Our Ref: 132043

RE: EIS Exhibition of SSD-10470 Woolworths Warehouse and Distribution Centre Auburn

Thank you for notifying Sydney Water of SSD-10470 at 11-13 Percy Street, Auburn, which proposes demolition of existing buildings on the site and construction and operation of a 20,615m² warehouse and distribution centre. Sydney Water has reviewed the application based on the information supplied and provides the following comments to assist in planning the servicing needs of the proposed development.

Drawing Title:
Elevations - Sheet 1

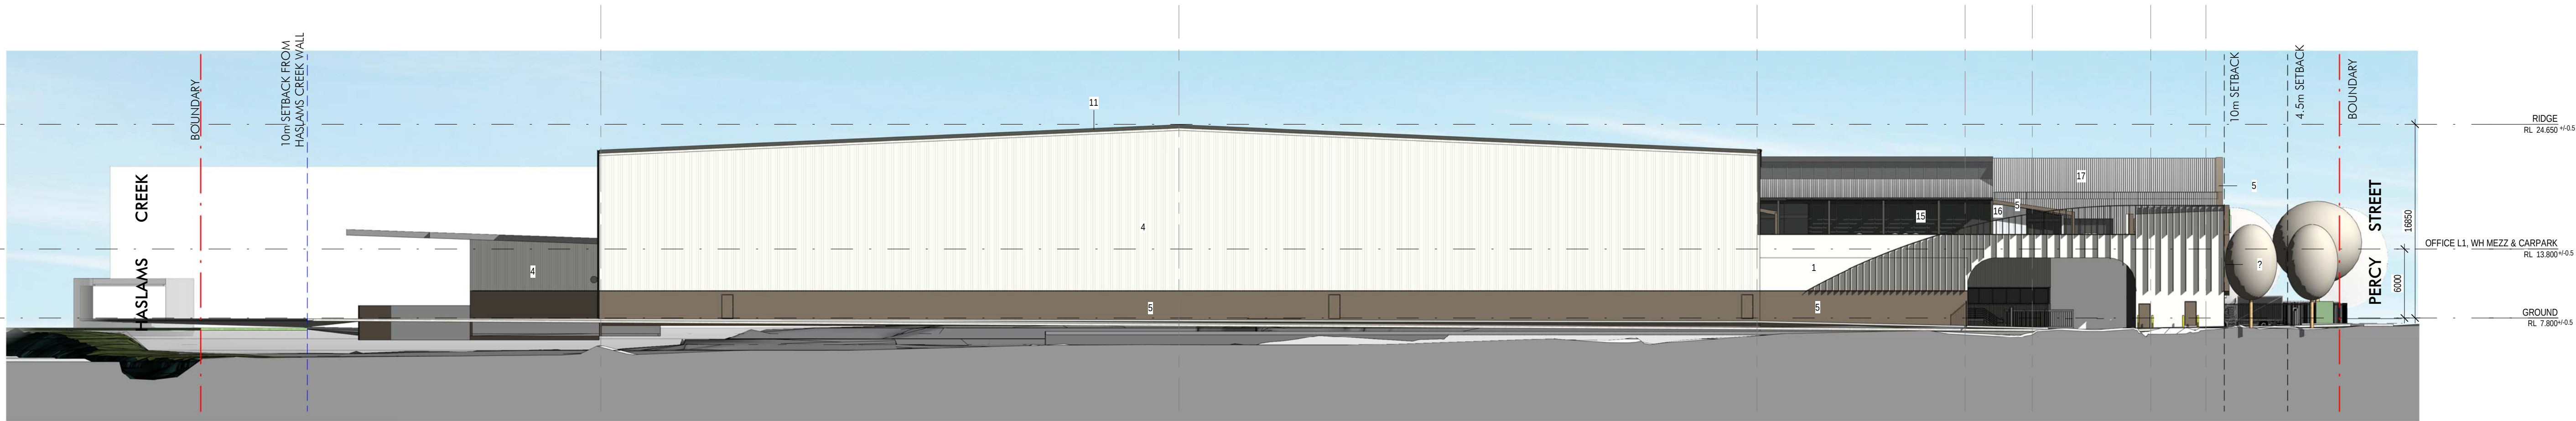
No building or permanent structure is to be proposed over the stormwater channel or within 1m from the outside wall of the channel. Permanent structures include (but are not limited to) basement car park, hanging balcony, roof eaves, hanging stairs, stormwater pits, stormwater pipes, elevated driveway, basement access or similar structures. This clearance requirement would apply for unlimited depth and height.

The applicant is required to submit the elevation drawings with the stormwater channel, to ensure that the proposed buildings and permanent structures are 1m away from the outside face of the stormwater channel.
